**WELWYN HATFIELD COUNCIL – DEVELOPMENT CONTROL**  
**DELEGATED REPORT**

<b>APPLICATION No:</b>	<b>S6/2011/2856/FP</b>
<b>APPLICATION Site:</b>	<b>42 Theobalds Road, Cuffley</b>

**DESCRIPTION OF PROPOSAL:**

DRWNG: FRONT AND REAR
ELEVATIONS PROPOSED

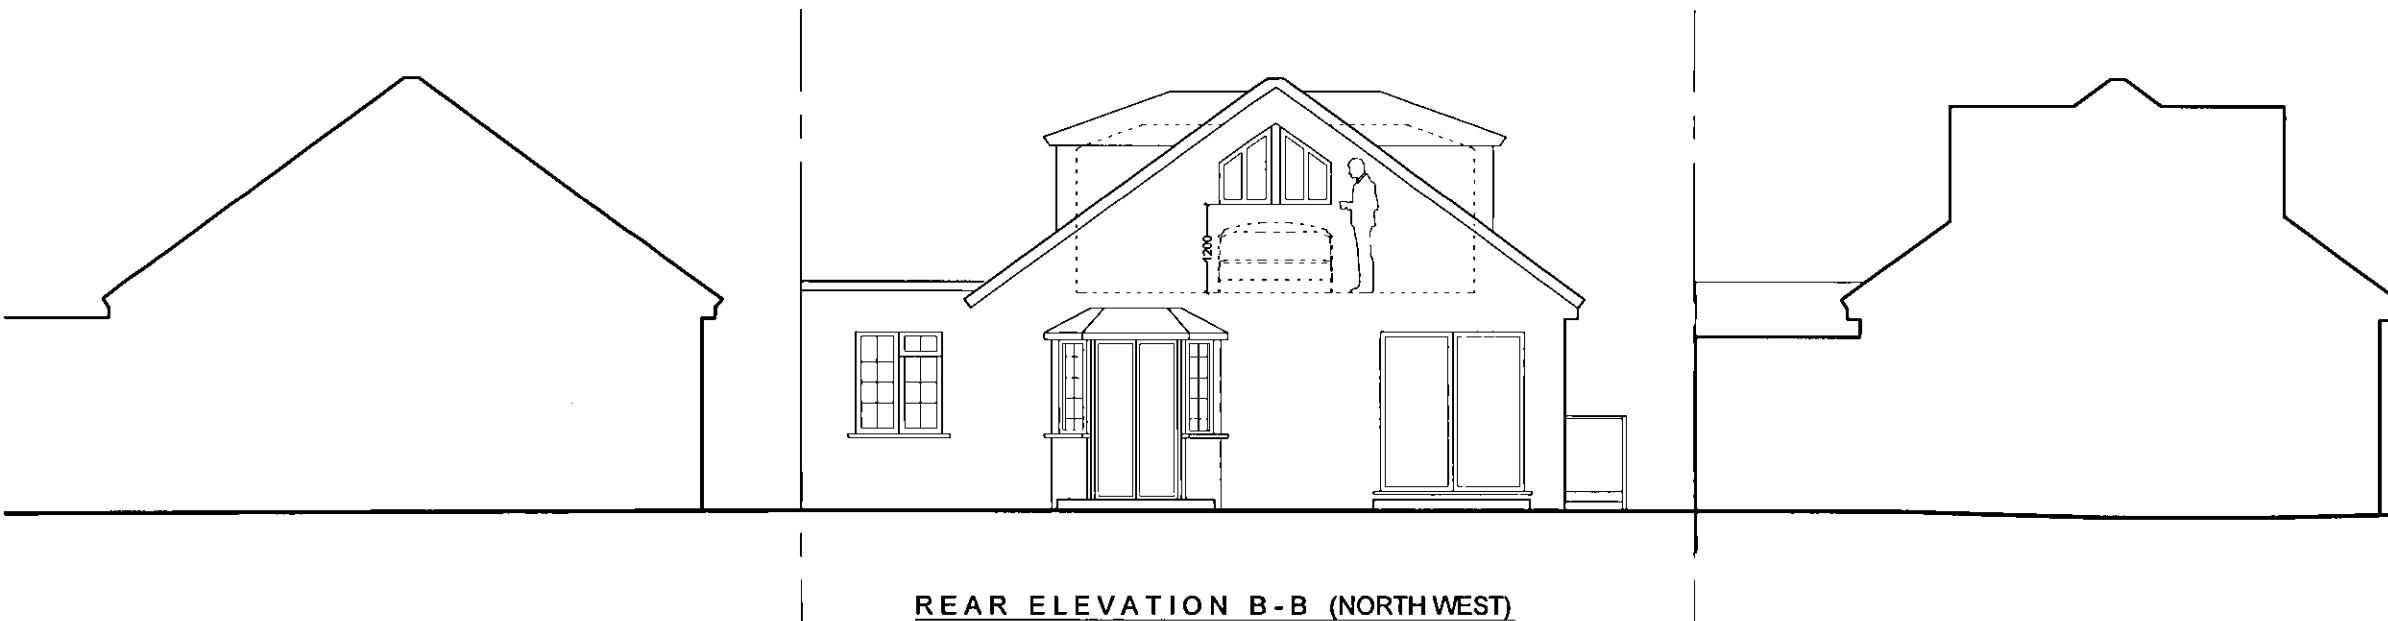
The proposal seeks planning permission for a rear extension measuring approximately 2m in depth. To the rear, the ridgeline of the existing roofline is proposed to be extended by 5.9m in depth creating a rear gable end at first floor level in line with the proposed ground floor rear extension. Four dormer windows are proposed, two on either side elevation of the roofspace.

The streetscene of Theobalds Road generally comprises of detached bungalows with hipped roofs. A number of these bungalows have created habitable rooms with the roofspace by incorporating hip to gable enlargements and dormer windows. The dwelling is situated within two dwellings which have both created hip to gable enlargements to the rear. The neighbouring dwelling to the south, No.44 has also incorporated four dormer windows. The proposed development at No.42 is not considered to appear overly prominent or detract from the character of the existing streetscene taking into consideration the development carried out to neighbouring dwellings. The proposed dormer windows will appear subservient and measure at least 1 metre from the flank boundary in accordance with policy D1 and paragraph 5.2 (vi) of the supplementary design guidance.

DRWG: SIDE ELEVATIONS  
PROPOSED

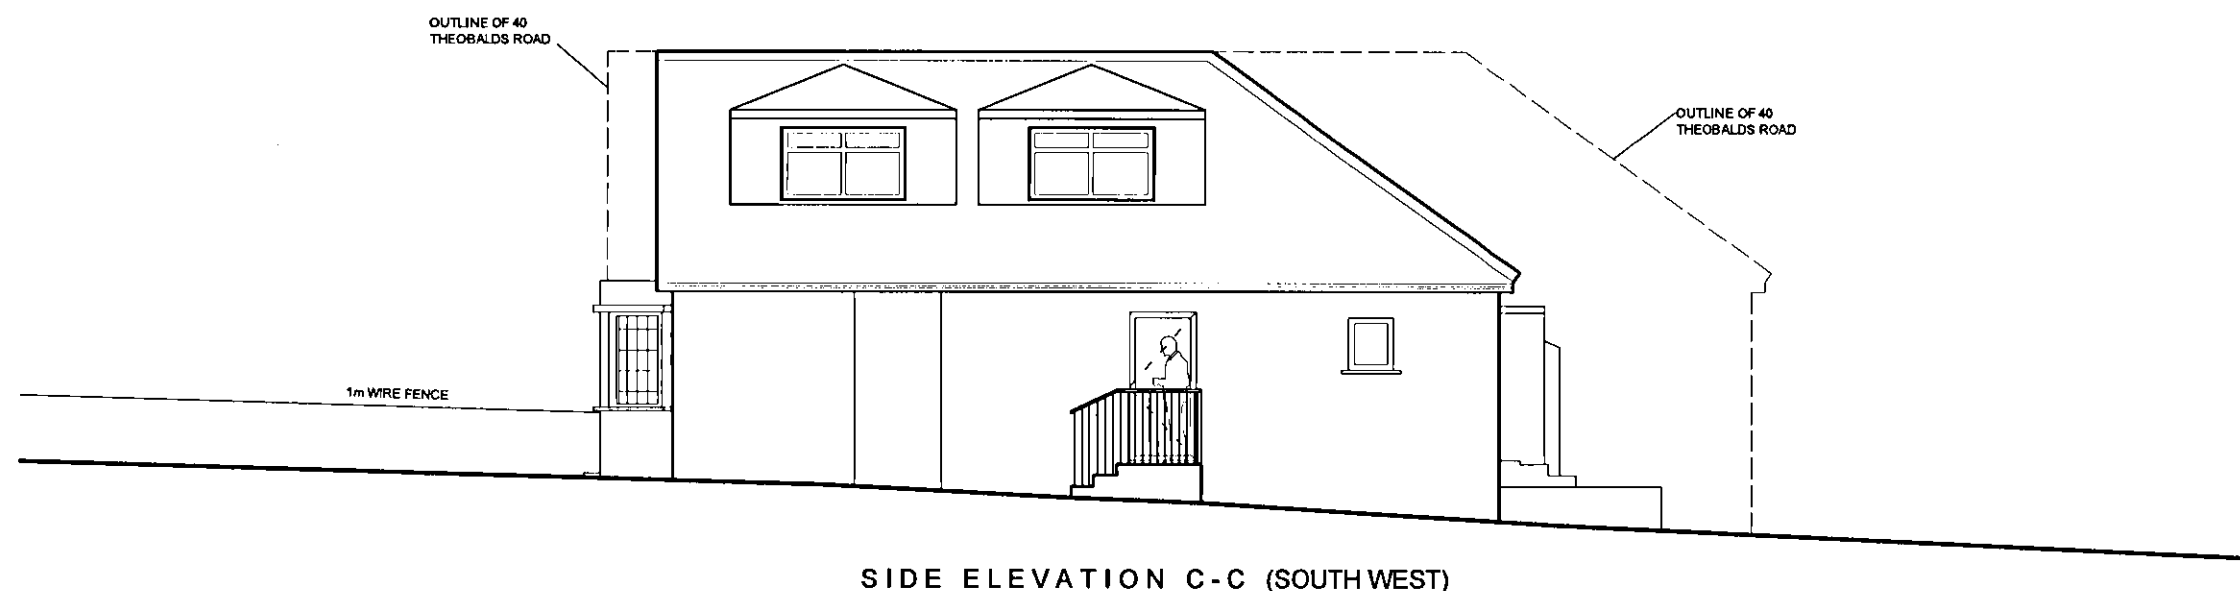
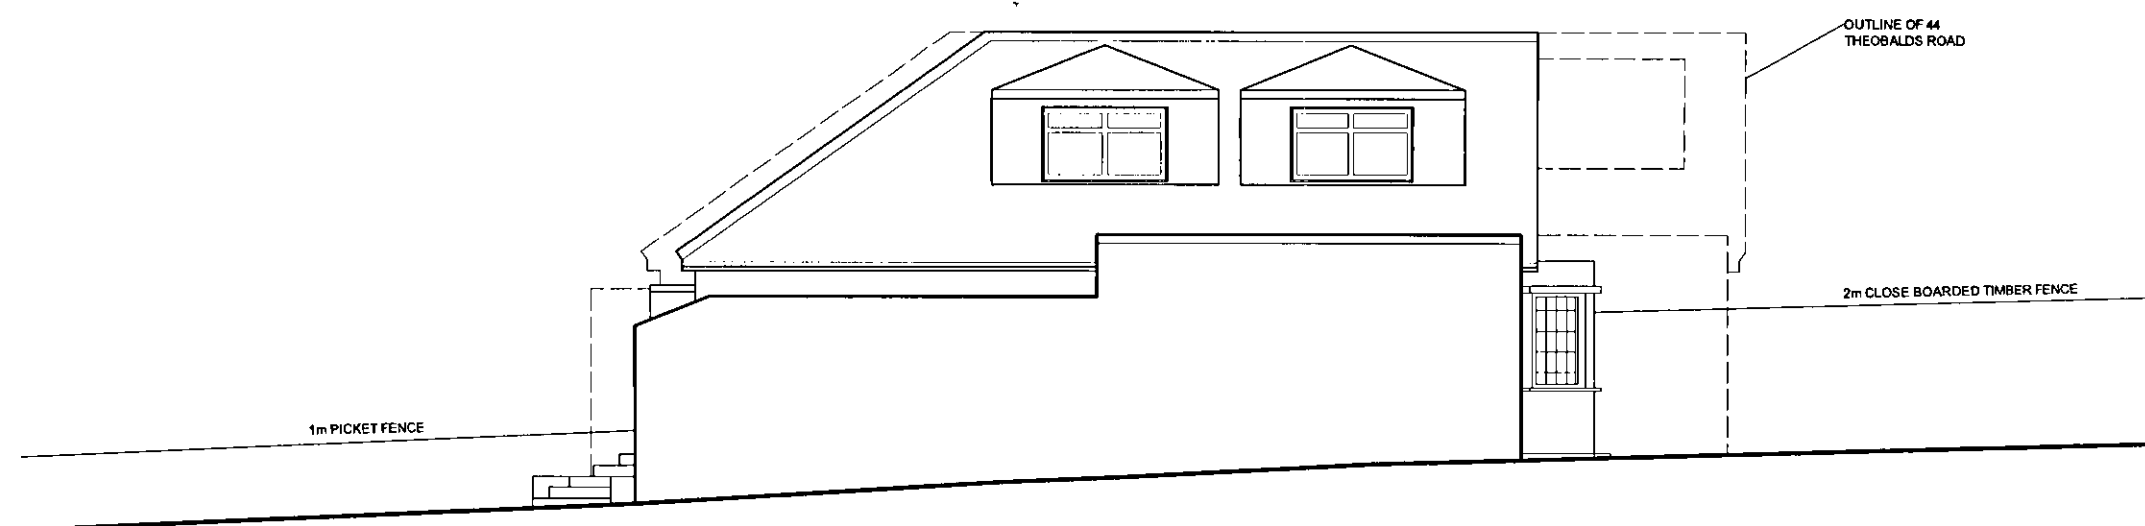
Northaw and Cuffley Parish Council have concerns that the dormer side windows may create an issue of overlooking.

This application has been advertised by neighbour notification letters and one representation has been received. The representation objects to this application as there are no plans showing the change in the roof space. The representation raises concern of overlooking.

The proposed dormer windows in relation to No.40 Theobalds Road are not considered to result in a detrimental loss of privacy or overlooking as no dormer windows or roof lights exist on the roofspace of No.40. Dormer windows exist at No. 44 Theobalds Road which would look onto the dormer windows proposed at No.42. However, the rear of the two dormer windows proposed on the southern side elevation is shown to form part of an ensuite and therefore it would be appropriate to condition the window to be obscure glazed and non opening below 1.7m. The other dormer window proposed on the southern side elevation will form part of a bedroom and is the only window serving this bedroom. For building control reasons it would not be appropriate to condition this window. However, the front of the two dormer windows on the side elevation of No.44 is shown to form part of the stairwell on the plans submitted under application reference (S6/1997/0901/FP) and as such the proposed dormer window at No.42 would not be overlooking a habitable room.

The proposed dormer window on the southern side elevation forming the ensuite shall be glazed with obscured glass and shall be fixed so as to be incapable of

being opened below a height of 1.7 metres above floor level, and shall be retained in that form thereafter.
